From: **Gino Aiello** gino@gjala.com
Subject: landscape comments 301 P
Date: February 22, 2016 at 4:18 PM
To: Robert G. Webster rwebster@rogers.com
Cc: Andrew Boyd aboyd@ifsassociates.ca

Landscape Plan, Commercial Development, 301 Palladium Drive, Kanata, ON, Drawing No.: L1, prepared by Gino J. Aiello Landscape Architect, August 2015, Revision 3 dated 15:10:20.

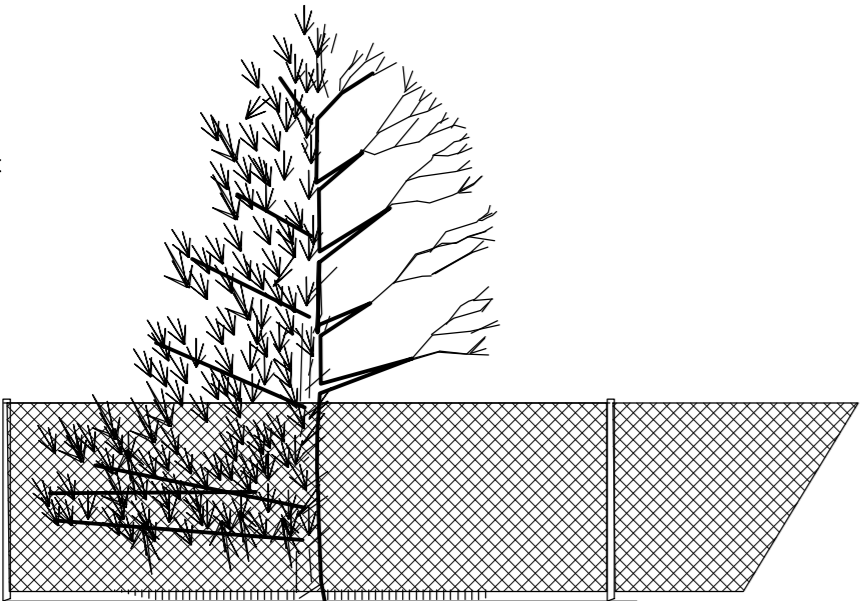
Existing tree inventory appears to be missing. -RESPONSE by GJALA - the detailed tree inventory is in the TCR - the pertinent details (Tree Protection) are shown on the landscape plan.

Parking lines should be updated to reflect site plan. RESPONSE by GJALA - We have updated this.

The Geotechnical Investigation Report indicates that trace silty clay deposits are present on the subject site. Please note that silty clay is highly sensitive to water depletion by trees of high demand during periods of dry weather that can lead to shrinkage of the clay material and potential settlement of any adjacent structures. The zone of influence is typically identified as approximately equal to the height of the tree. Please consult with geotechnical consultant to determine if the soil is a concern for shrinkage and for recommendations to incorporate into the proposed design of the onsite tree layout.

RESPONSE by GJALA - we have discussed this with the DST, they have included a recommendation in their revised report and we have respected their report.

Picture 1. Spruce trees 1 through 4 at 301 Palladium Drive.

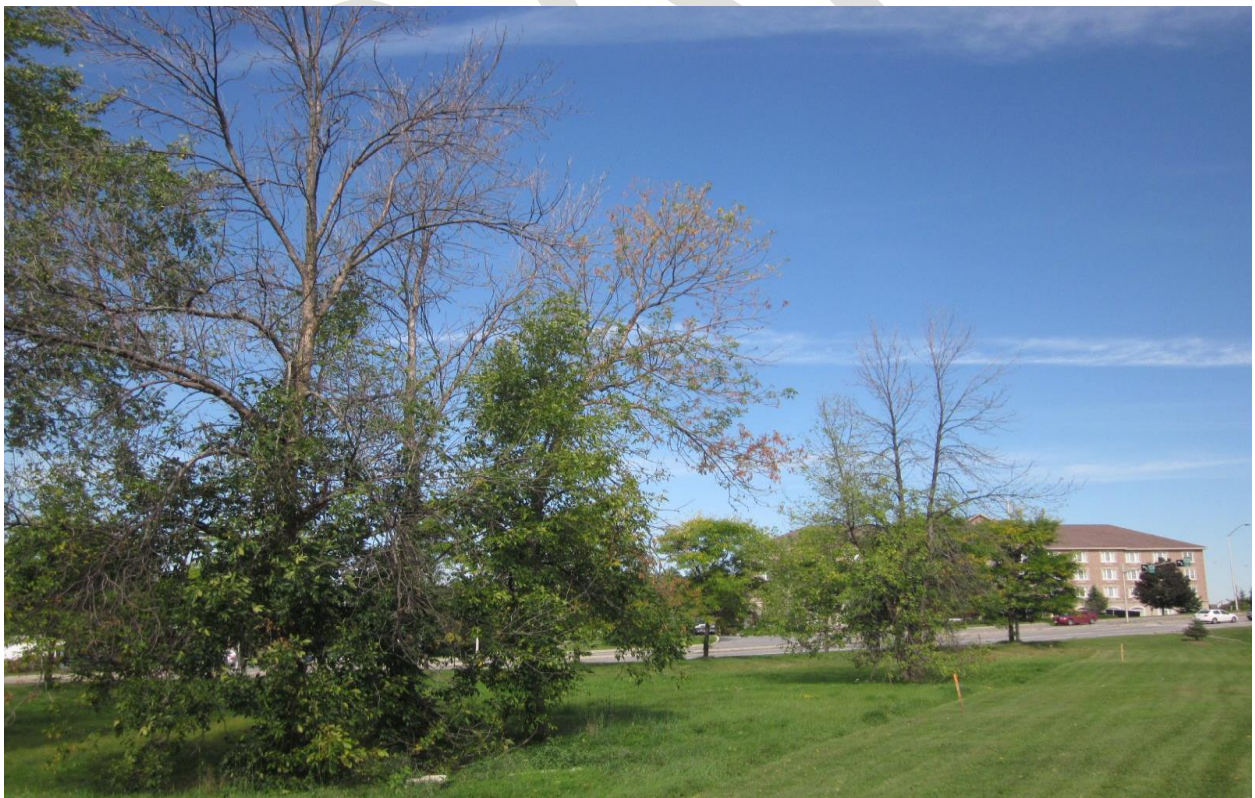
Table 1 of the TCR indicates that trees 3 & 4 are "to be retained". However, the attached figure indicates that trees 3 & 4 are to be removed. Clarification on the intent of these trees should be provided. RESPONSE - by GJALA - tree 3 and 4 are newly planted spruce and will be transplanted slightly east as per the revised plan/TCR

If the required number of parking spaces proposed exceeds what is required, it may be possible to retain trees 3 & 4. RESPONSE - by GJALA - tree 3 and 4 are newly planted spruce and will be transplanted slightly east as per the revised plan/TCR

In the TCR, trees 3 and 4 are indicated as to be retained in Table 1; I suspect they are mislabelled and are proposed to be removed. Please correct the error in the TCR. RESPONSE - by GJALA - tree 3 and 4 are newly planted spruce and will be transplanted slightly east as per the revised plan/TCR
